**Ref No:** F2020/00663

Application No: SSD-10831778

**Re: Randwick City Council submission on the State Significant Development SSD-10831778 – Sydney Children’s Hospital Stage 1 and Children’s Comprehensive Campus Centre (SSD-10831778)**

5 PROPOSED HOURLY SHADOWS - JUNE 21 - 12 PM
1 : 1500

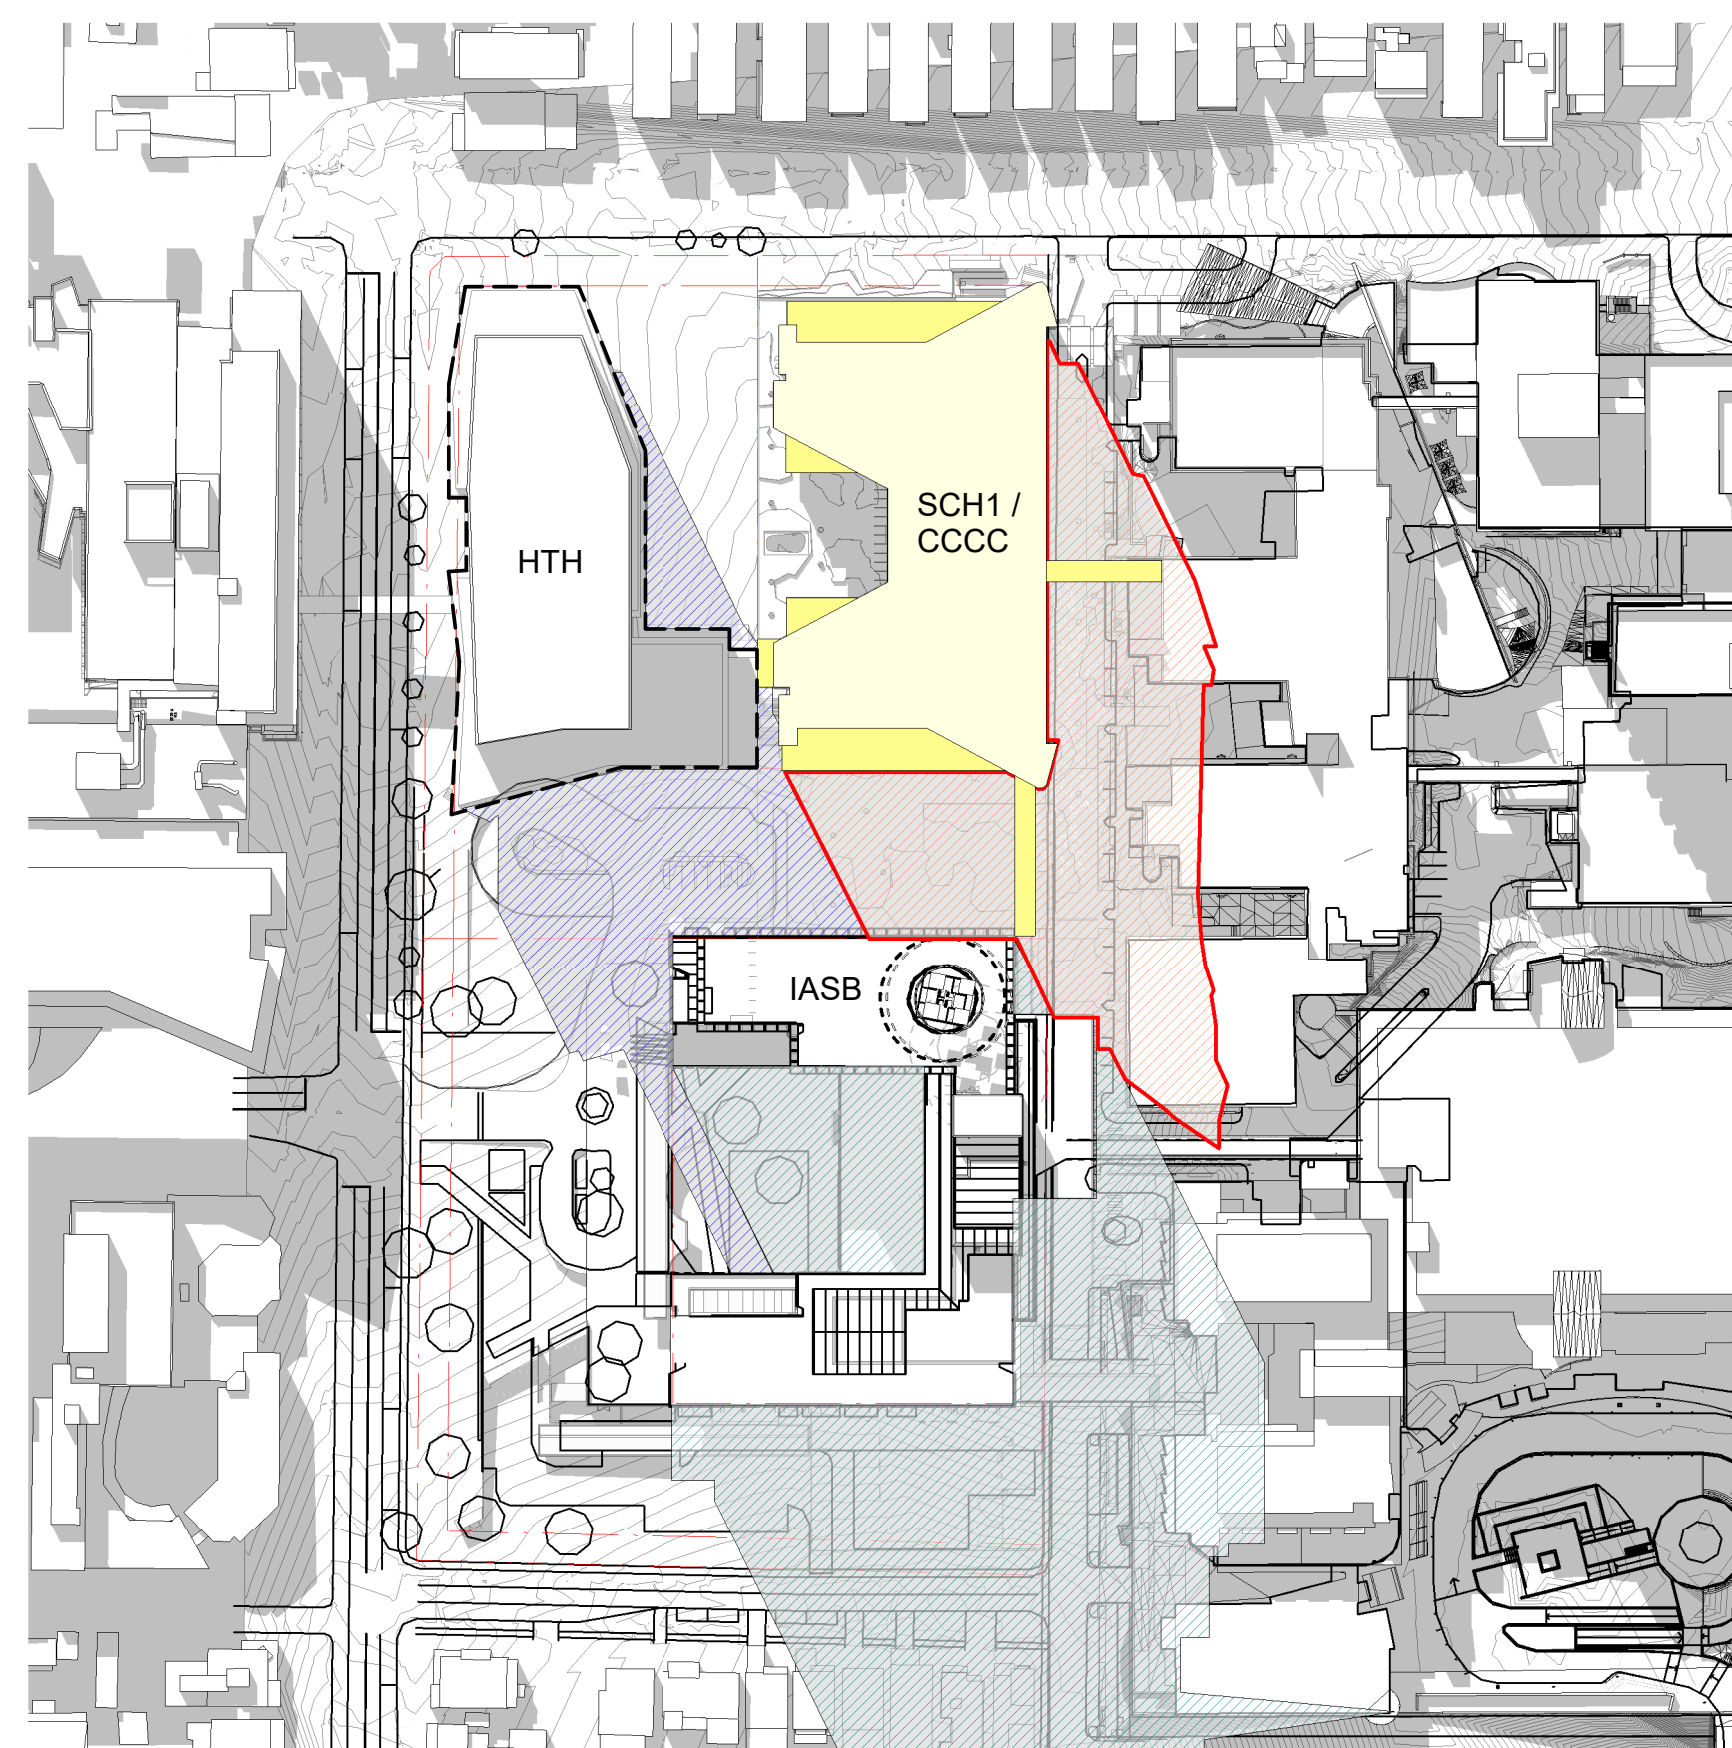
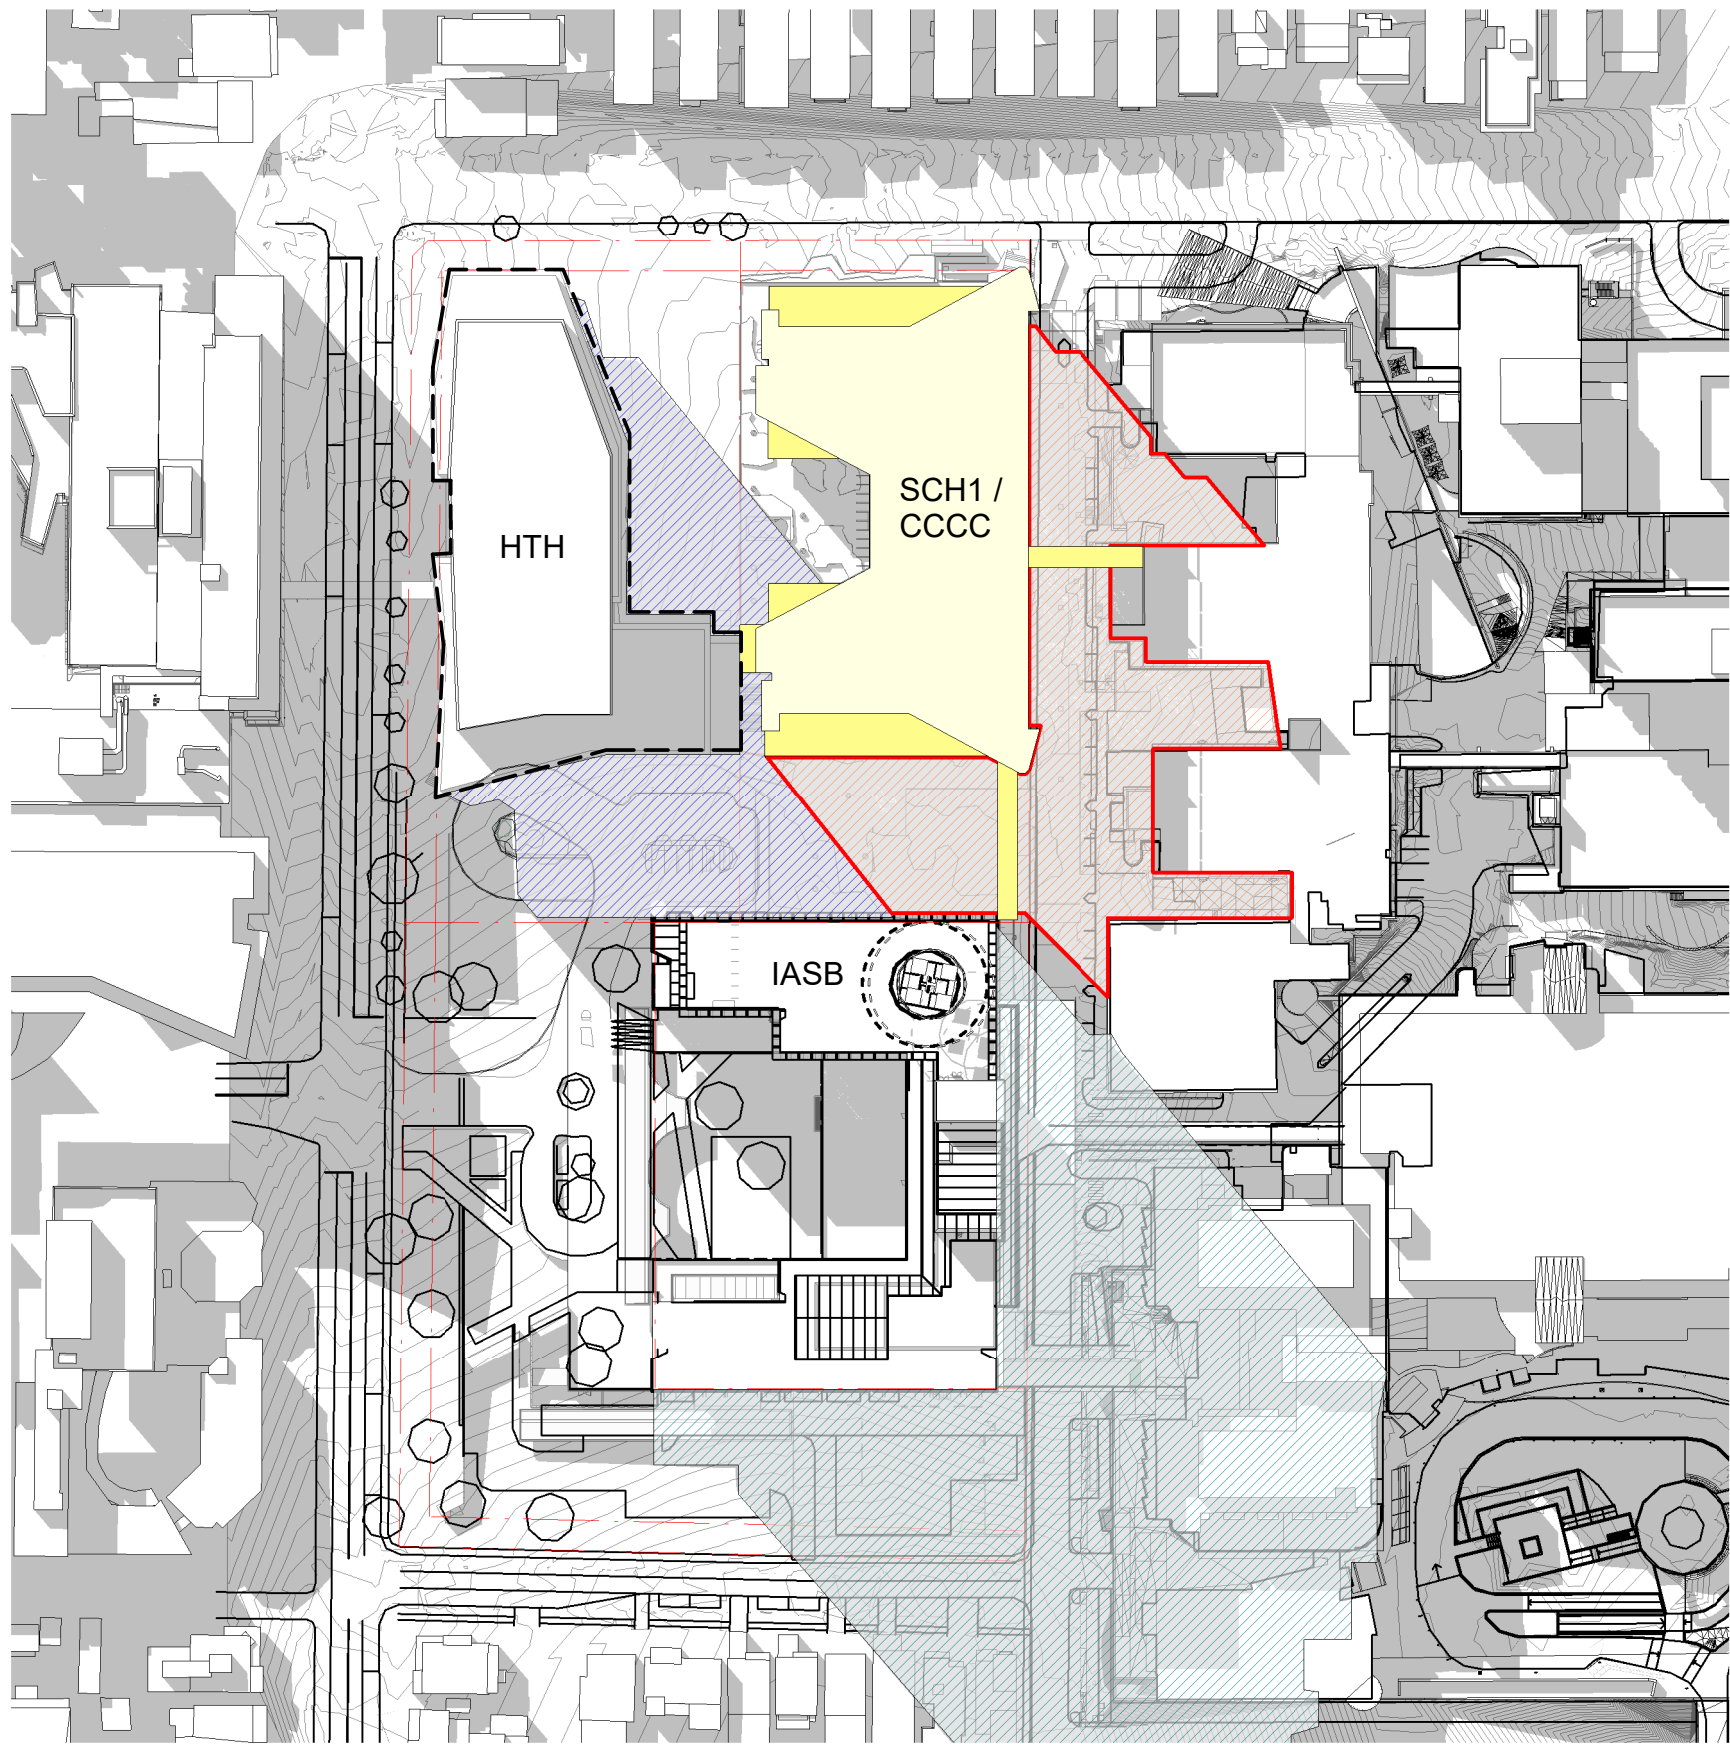
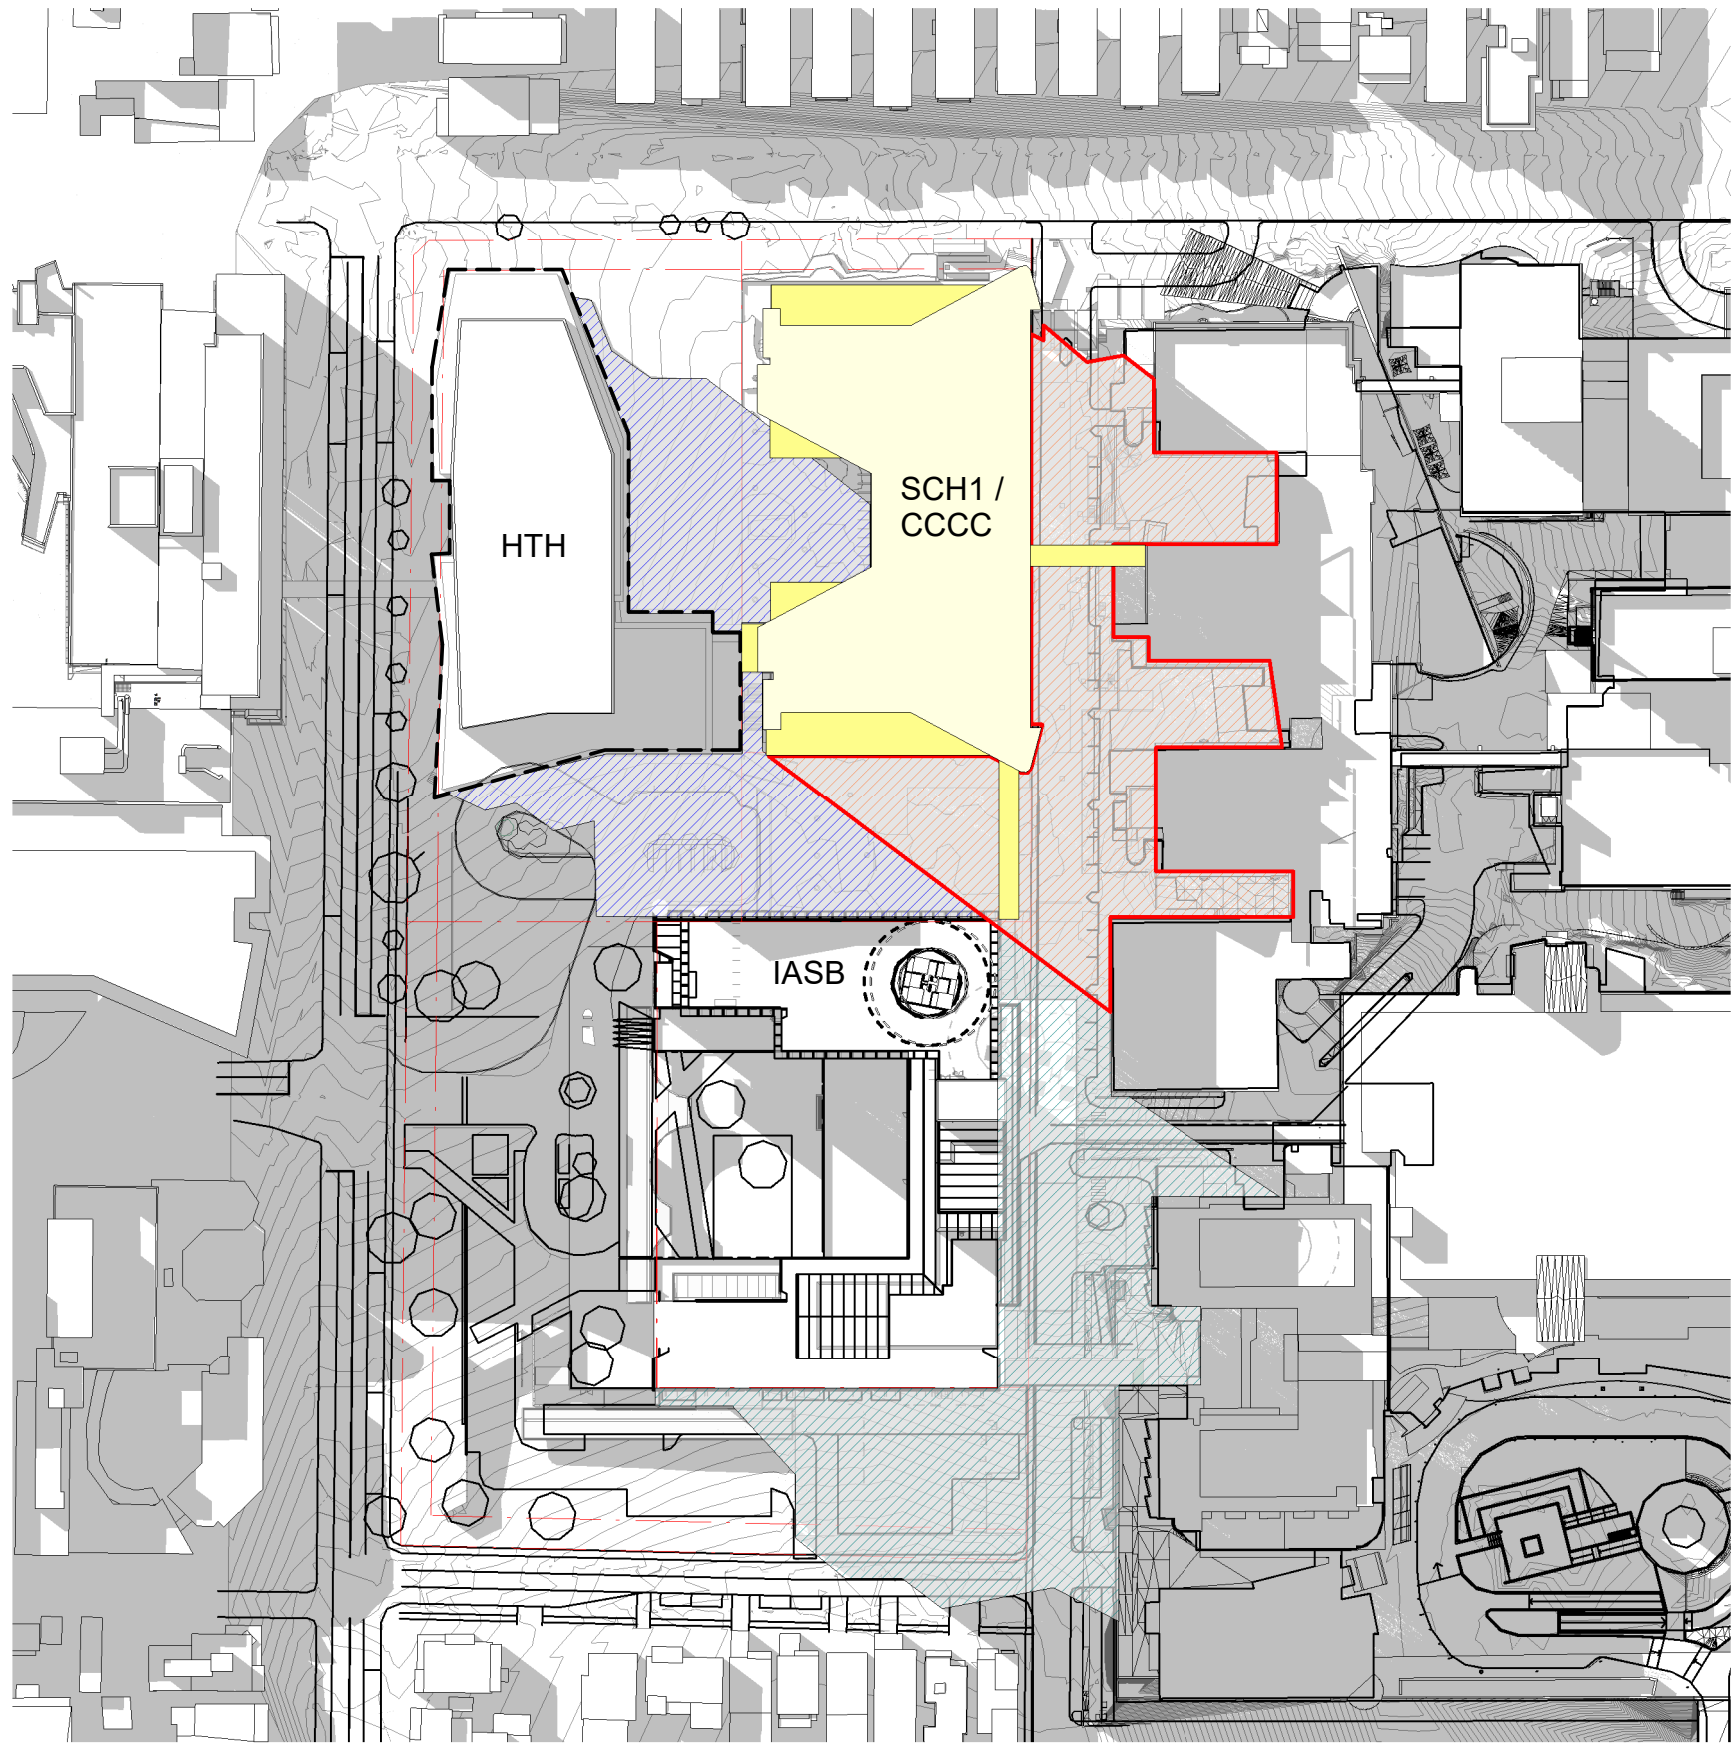
33. Shadow studies should be provided at hourly intervals for the winter solstice to assess solar access to the key public domain areas such as the plaza and children's play area.
